RE: SP-23-00003 Hauglum Short Plat

**TO:** All Staff  
**FROM:** Public Works Plan Review Team  
**DATE:** June 16<sup>th</sup>, 2023  
**SUBJECT:** Public Works Comments: SP-23-00003 Hauglum

HAUGLUM SHORT PLAT PART OF SECTION 34, T. 20 N., R. 15 E., W.M. KITITAS COUNTY, WASHINGTON

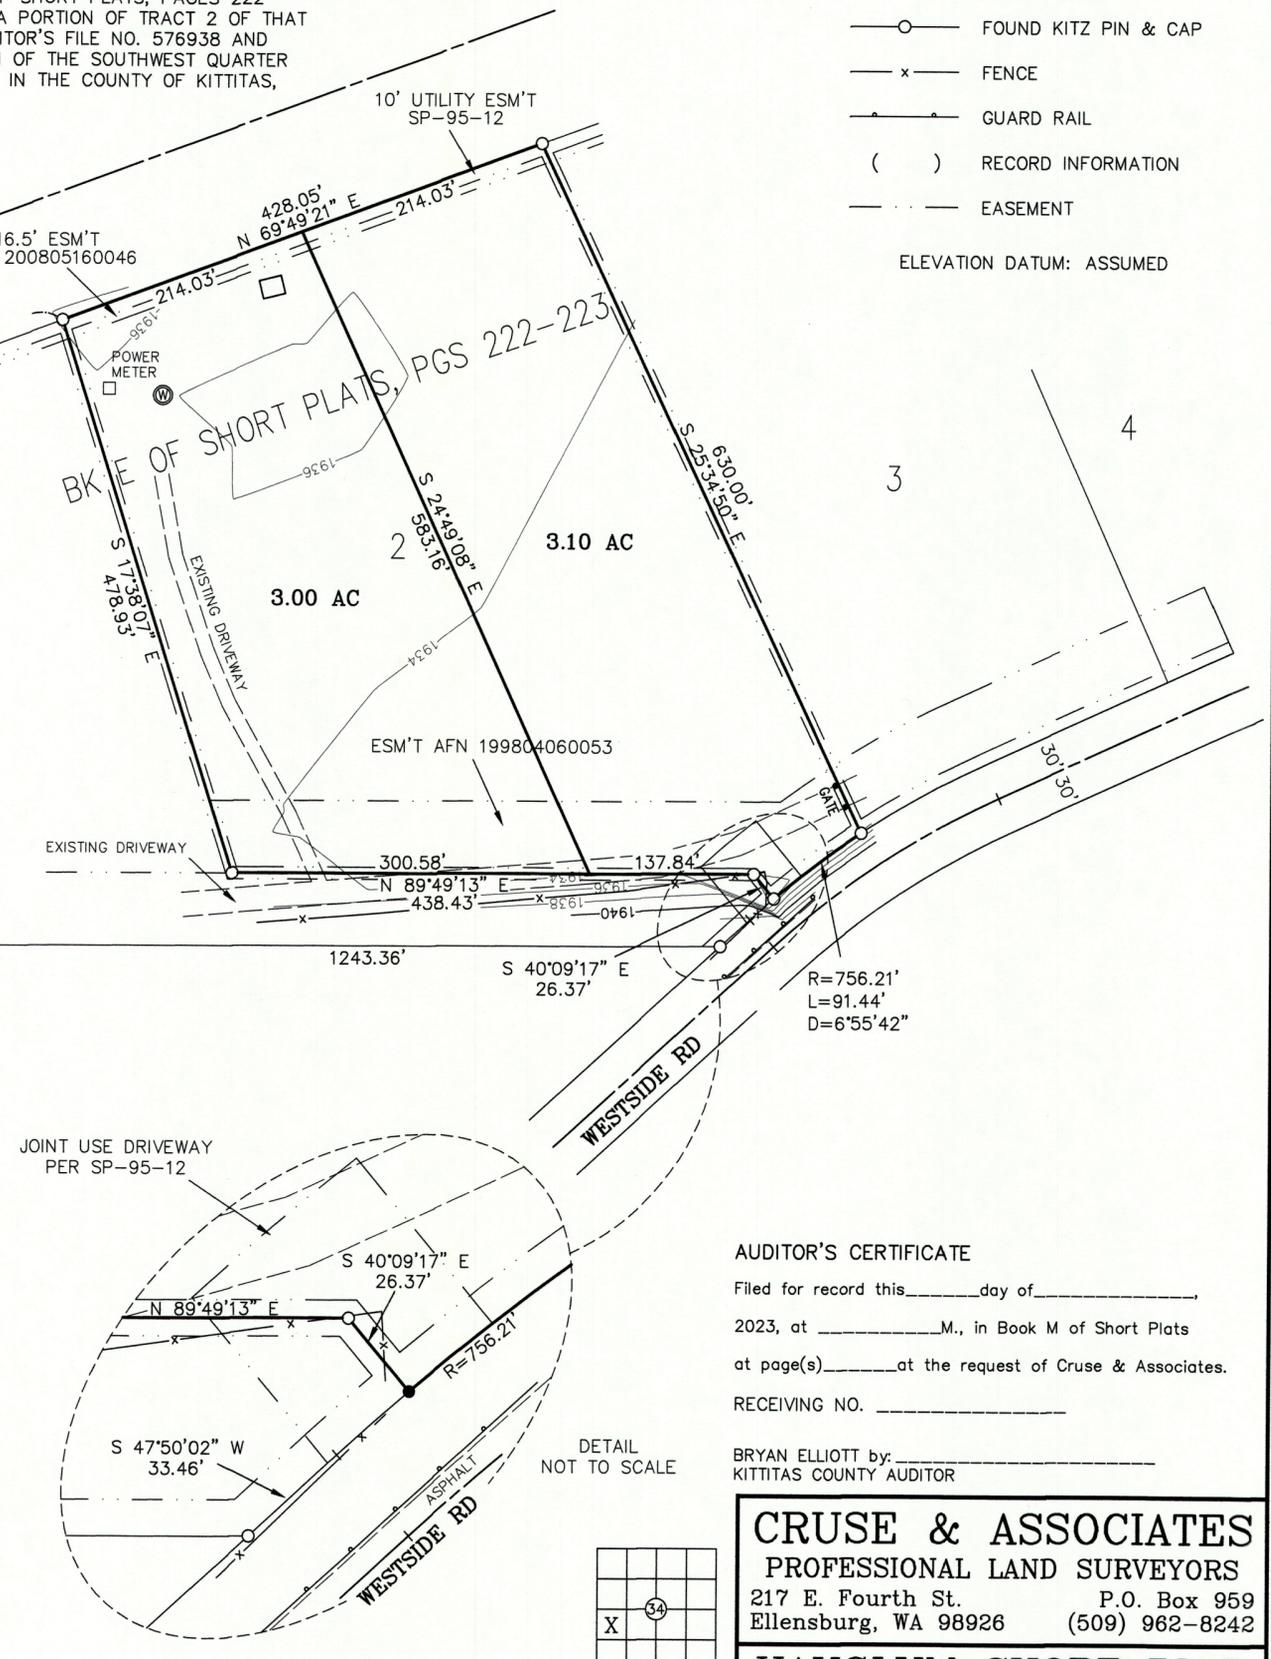
<b>SURVEY</b>	<ol style="list-style-type: none"> <li>1. The Prelim Short Plat provided does not meet the requirements of WAC 332-130-145. Survey proposes a resubmittal that addresses these requirements.</li> <li>2. Per Compass GIS map, there are multiple structures on site that do not appear on the face of the Short Plat. In the event these were removed, a statement from the surveyor will be sufficient.</li> </ol> <p>Prior to final approval, the following elements will need to be addressed:</p> <ol style="list-style-type: none"> <li>1. The joint use driveway easement should reference Volume and Page or AFN, not CDS's application number.</li> <li>2. The S'most found property corner shown has a break in the distance ties. Please include the missing curve data, so that this is tied to the survey. Doing this will eliminate the need for comment #3 below.</li> <li>3. As the Curve coincident with the North line of Westside road is non-tangential, please include a chord bearing and distance OR show the bearings of radii at start and end of the curve. (JT)</li> </ol>
